Application Ref:	3/2021/0319	 Ribble Valley Borough Council www.ribblevalley.gov.uk
Date Inspected:	22/04/2021 and 20/05/2021	
Officer:	AD	
DELEGATED ITEM FILE REPORT:		Decision Refusal

Development Description:	Design amendments to previous approvals 3/2018/0455 and 3/2019/0467 for one 3 storey dwelling.
Site Address/Location:	Land Adjacent to 39 Clitheroe Road Whalley BB7 9AD

Title:
TREE IMPACT PLAN
 in Relation to Proposed Construction of Detached Two-Storey Residential Property

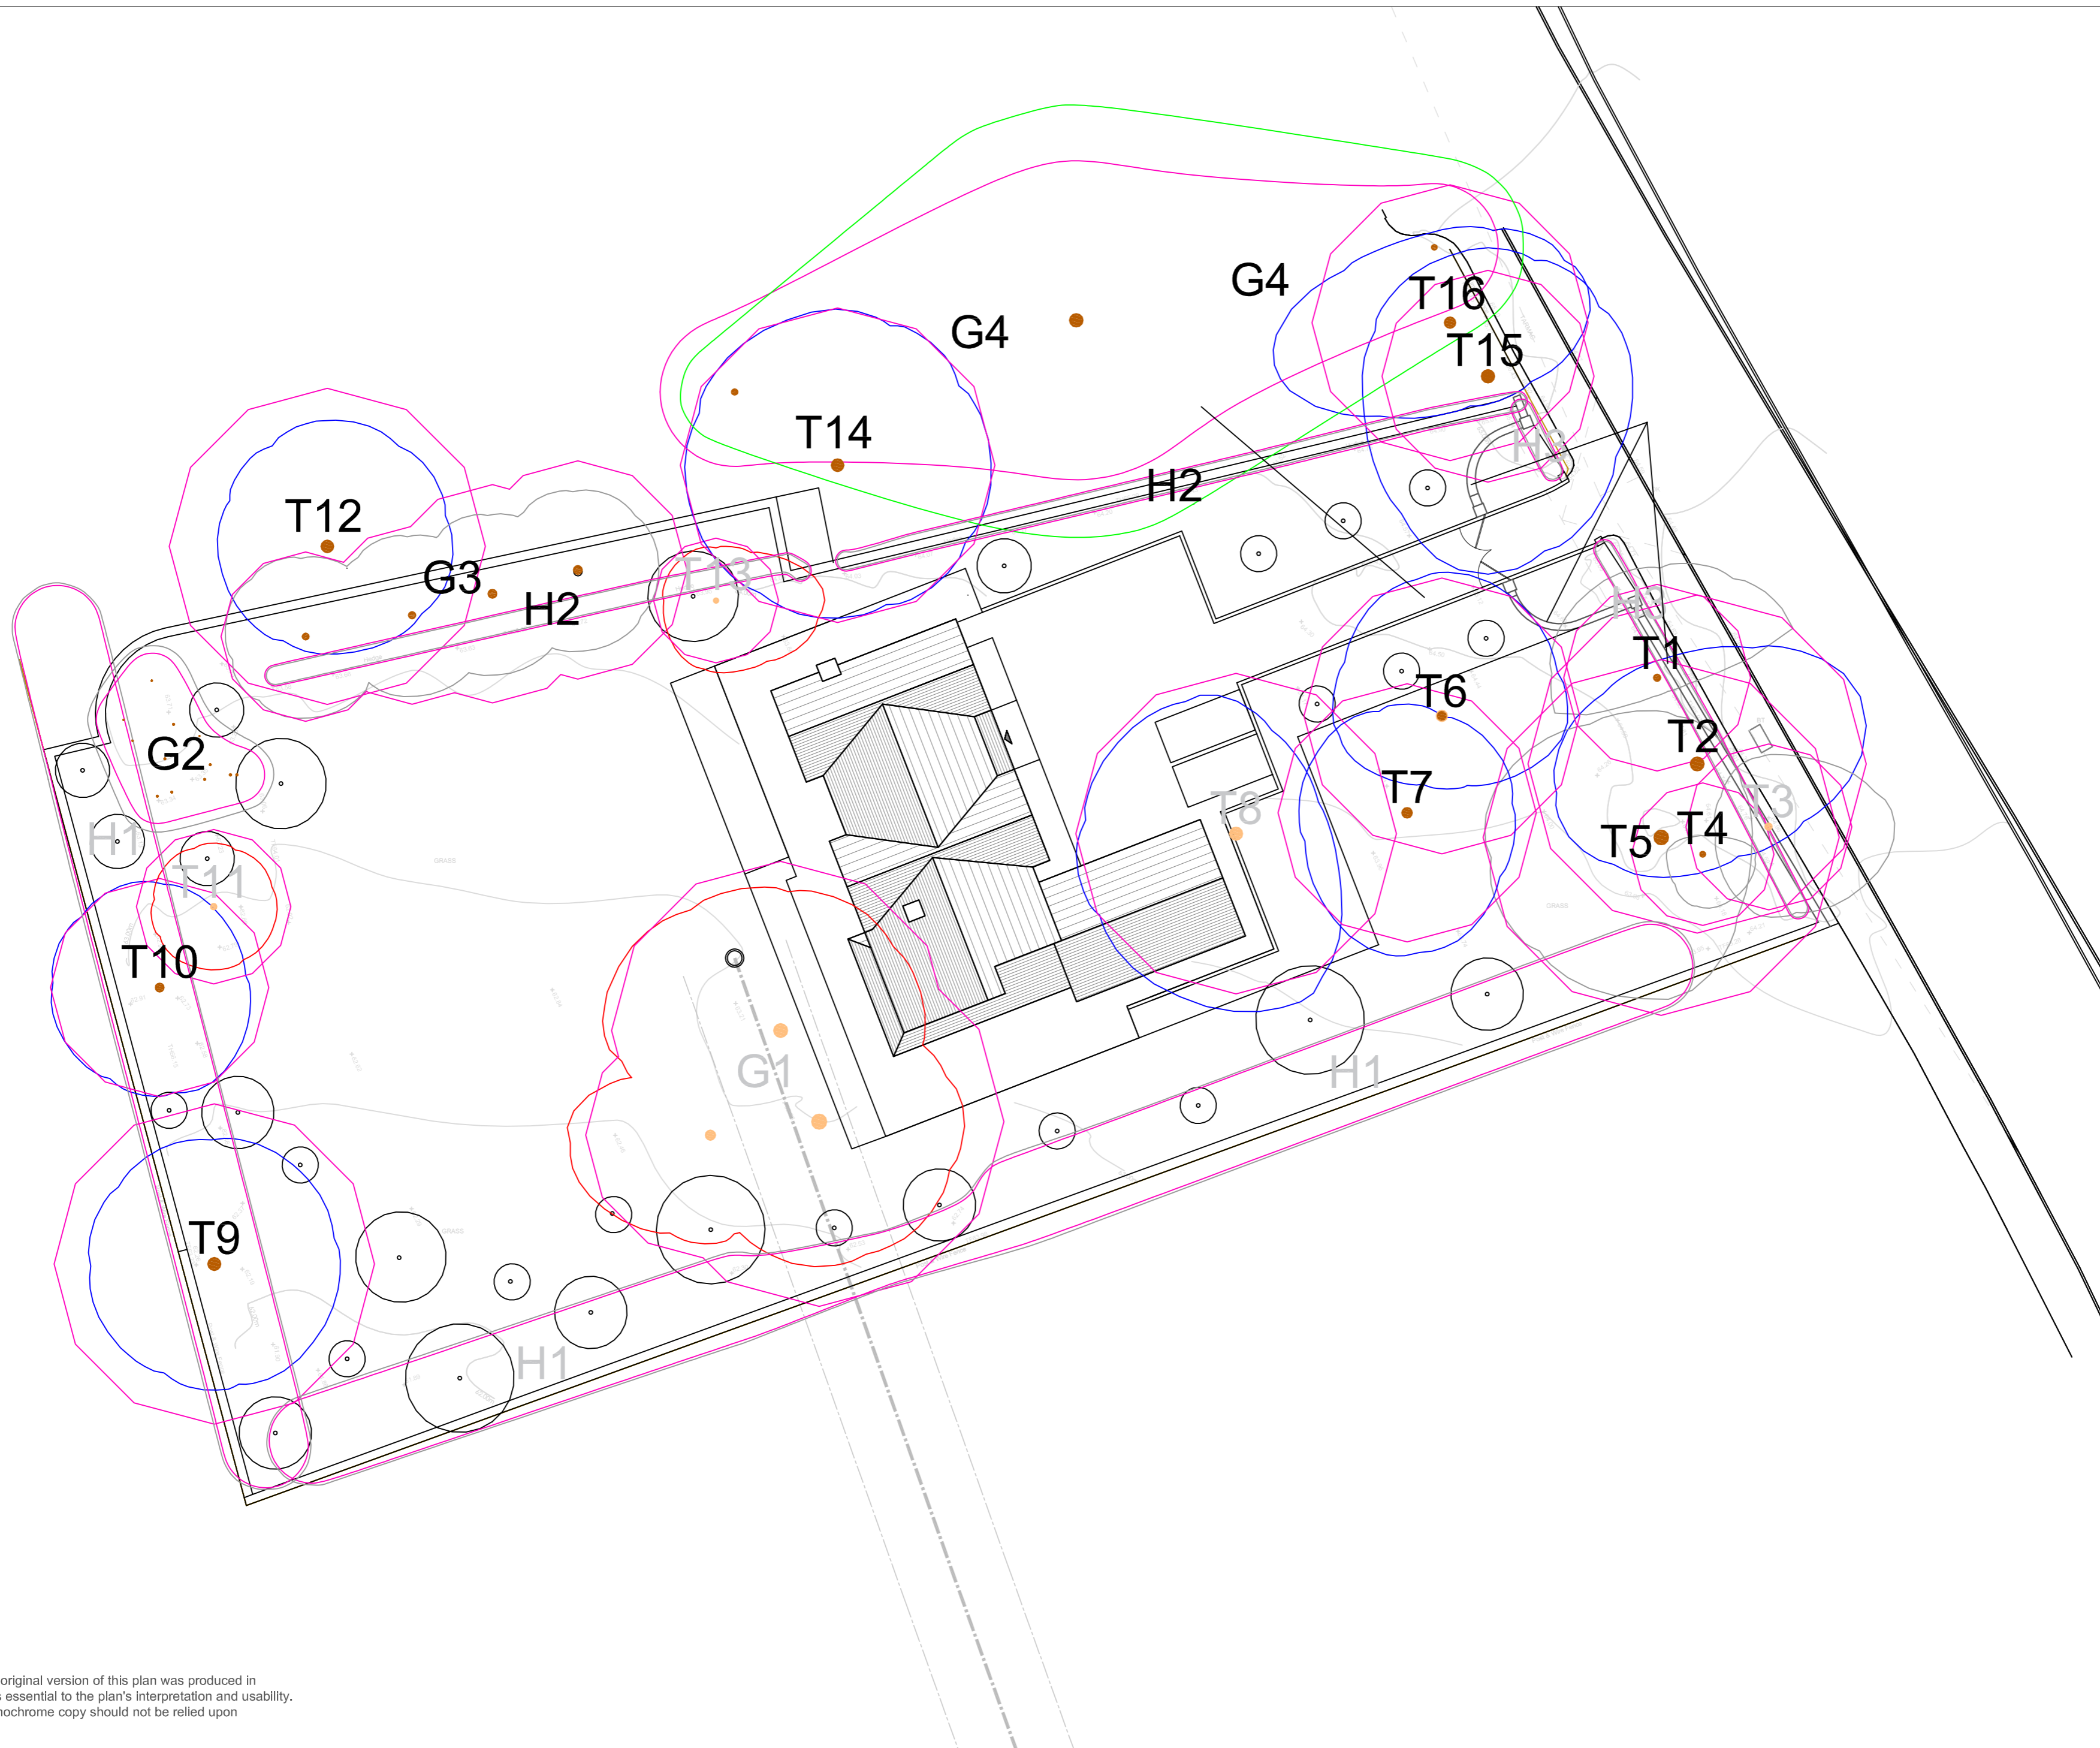
There is substantial tree screening to the north and south and significant building separation distances. However, the submitted Arboricultural Impact Assessment (July 2019) identifies removal of the southern hedgerow “in context of site landscaping” which has not been submitted (previous schemes have identified replanting i.e. both 3/2018/0455 and 3/2019/ 0467 “Remove in full and replace with native Hawthorn hedge, as indicated on Planting Proposals plan by Rycroft Associates”). Furthermore, the impact of the new swimming pool/gym block on existing or proposed landscaping along the southern boundary has not been explained. The impact of overlooking from the proposed structure (substantially glazed south elevation) cannot be fully gauged.
